CITY OF ALBUQUERQUE

October 19, 2021

**Re: Dutch Bros Coffee
Project Address ???
Traffic Circulation Layout
Engineer's Stamp 10-07-2021 (B10-D003I)**

C-100

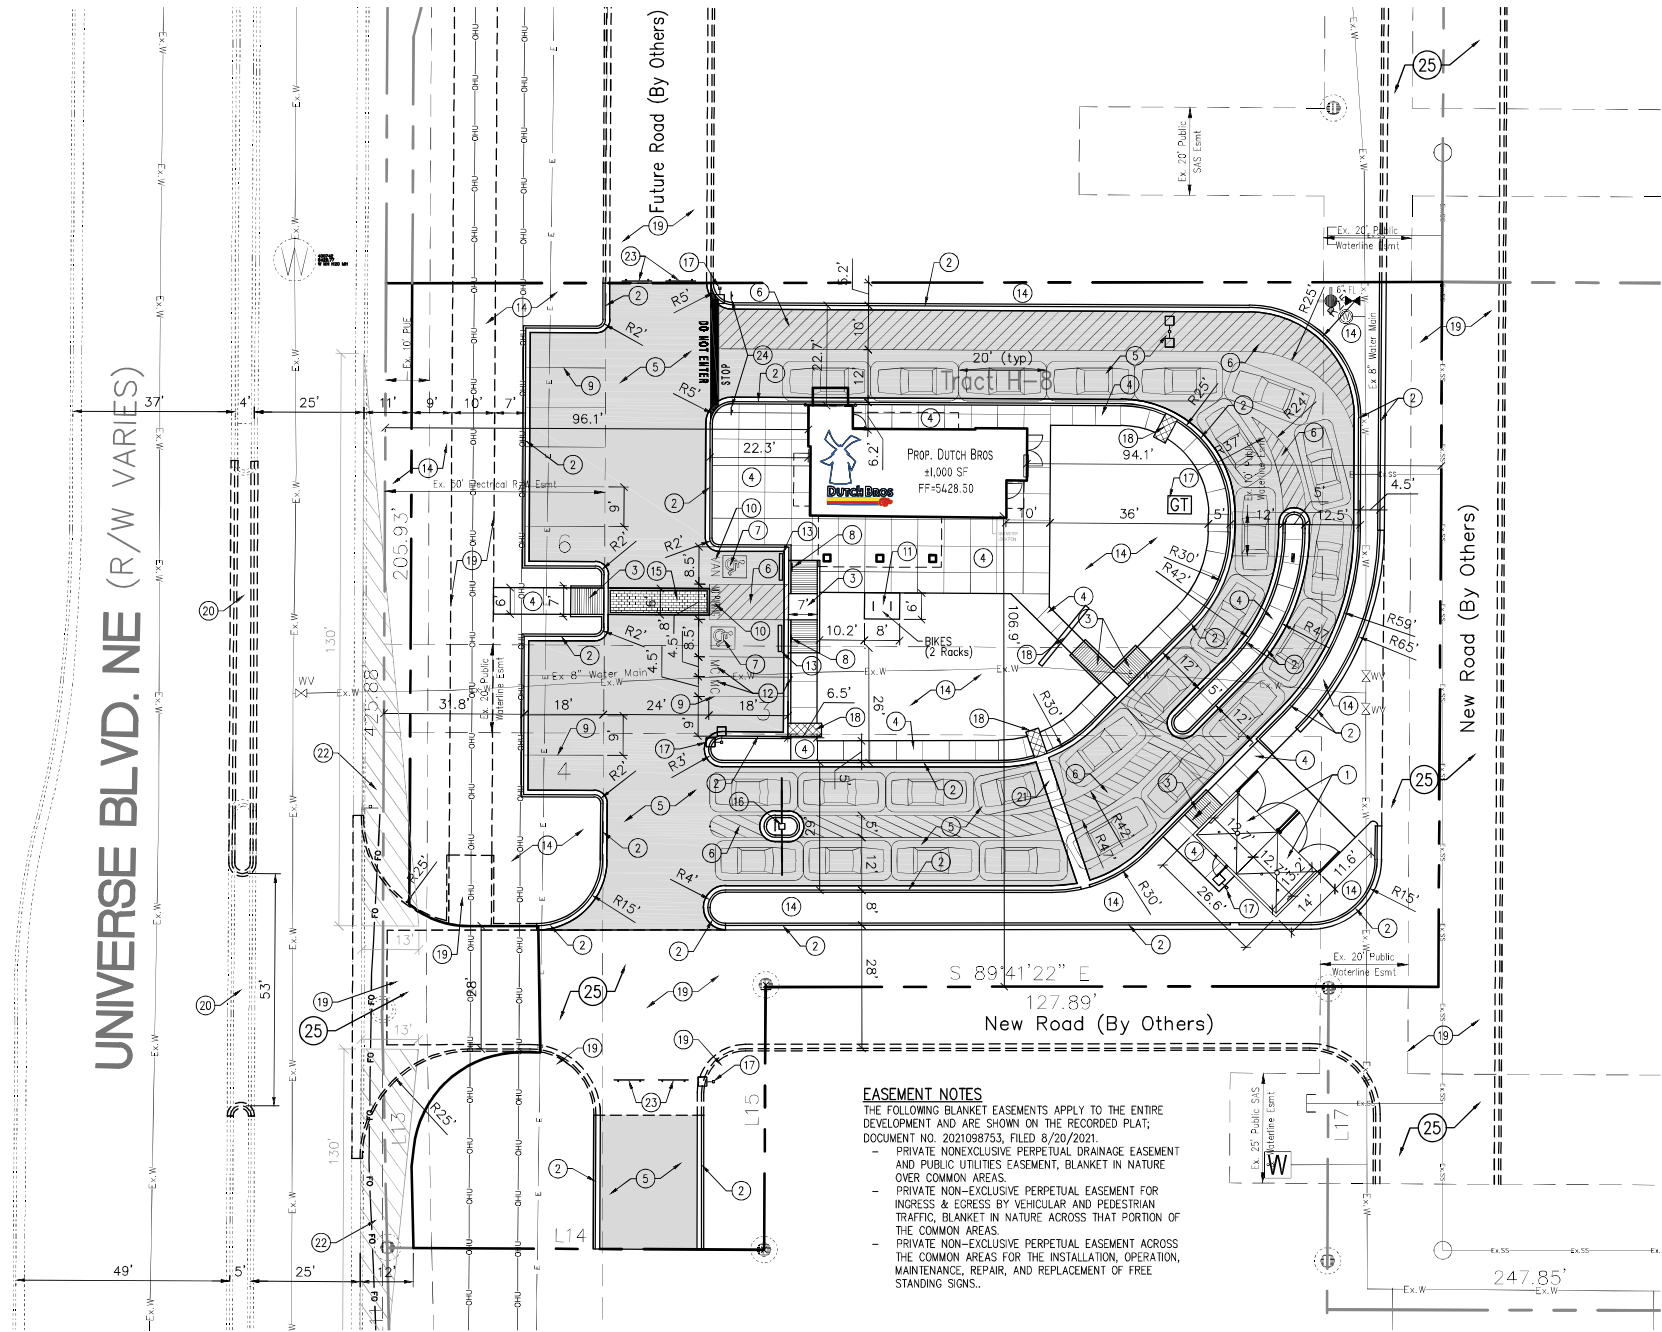
1. Pavement Limits will need to be provided for the following:

- Universe entrance Work Order versus TCL project. Limits will need to be provided.
- Drive Aisle limits west of turn off to Dutch Bros toward interior lots.

2. Keyed Note 23, provide on the following locations:

- Drive aisle entrance to Lot H-10.
- Drive aisle segment beyond Dutch Bros turn off toward interior lots.

3. **Keyed Note 2:** You shown arrow pointing at northern property line. Is there something missing? Please clear up this concern.

4. **Keyed Note 5:** Please reference COA details for Pavement design or explain why you are referencing NMDOT.

5. **Keyed Note 6:** You shown arrow pointing to entrance drive into Dutch Bros but not detail is shown. Clear up arrow

6. **Keyed Note 8:** This note has referenced sheet C-400! Do you mean sheet C-101? Please clarify.

7. **Keyed Note 16:** Please provide details on sheet C-101 instead of referencing **ARCHITECTURAL PLANS.**

8. Proposed Drive Through:

- A queuing analysis will need to be provided.
- Provide the queue length per DPM requirements. Show drive thru order window and pickup window (label).

9. **Keyed Note 22:** Provide note onto Universe southern entrance segment as shown on site plan but not labeled.

F1

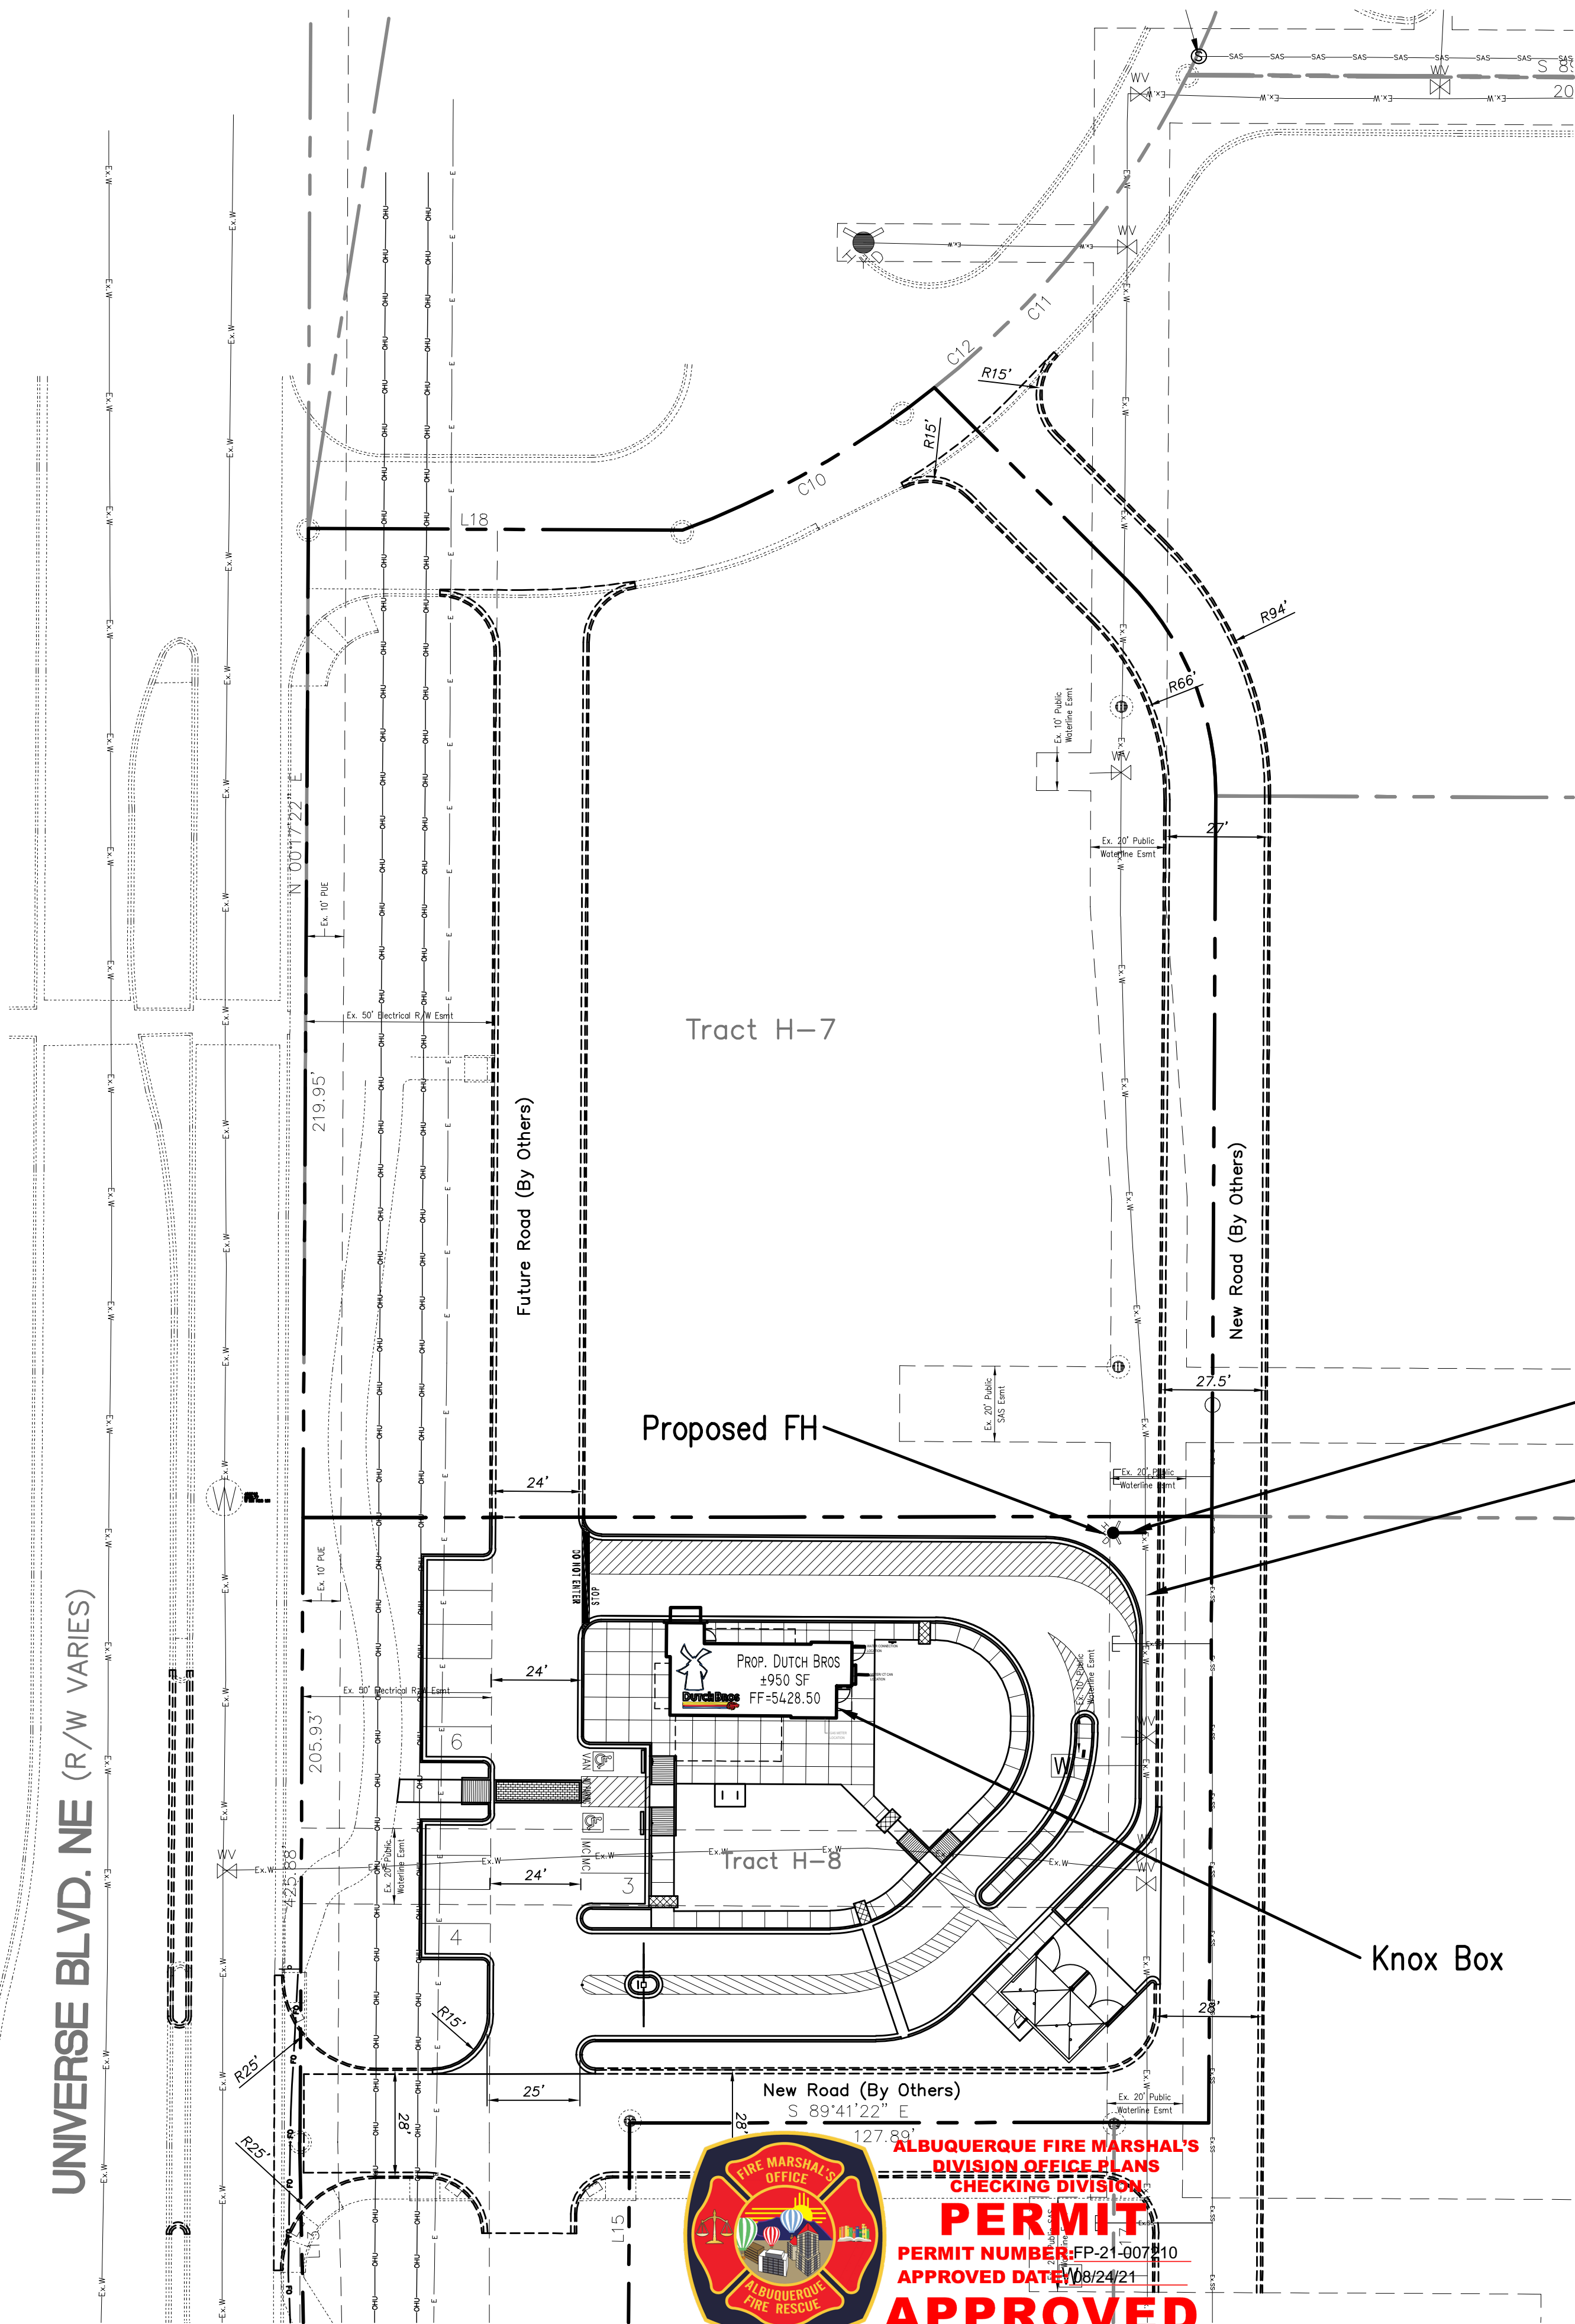
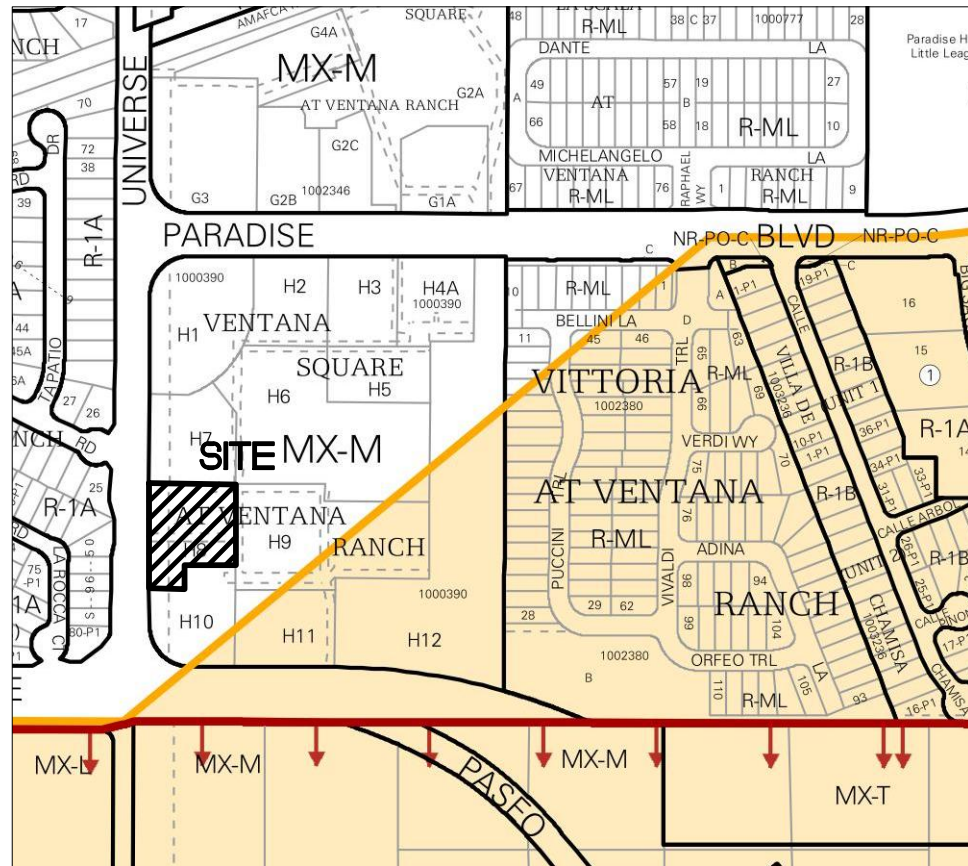
10. **Fire 1 Plan:** An approved plan, **with stamp and signature**, will need to be provided. I spoke with Inspector Louis on the 4th floor and he needs you to provide the TCL pavement limits(only). TCL plans will need to stand alone until all roadway infrastructure is in place.
11. **The proposed ADA ramp off ADA parking access aisle width will need to be provided.**
12. **The prior comment was only half addressed:**All one-way drives shall have "One Way" and "Do Not Enter" signage. Please show detail of posted signs.
13. **Shared Site access:** Provide copy of Plat demonstrating verbiage and exhibit for Blanket Easements.
14. Please provide a letter of response for all comments given.
15. **Traffic Studies:** Provide the APPROVED Traffic Impact Study (TIS).
16. Resubmittal fee receipt will need to be provided. **An invoice has been sent.**
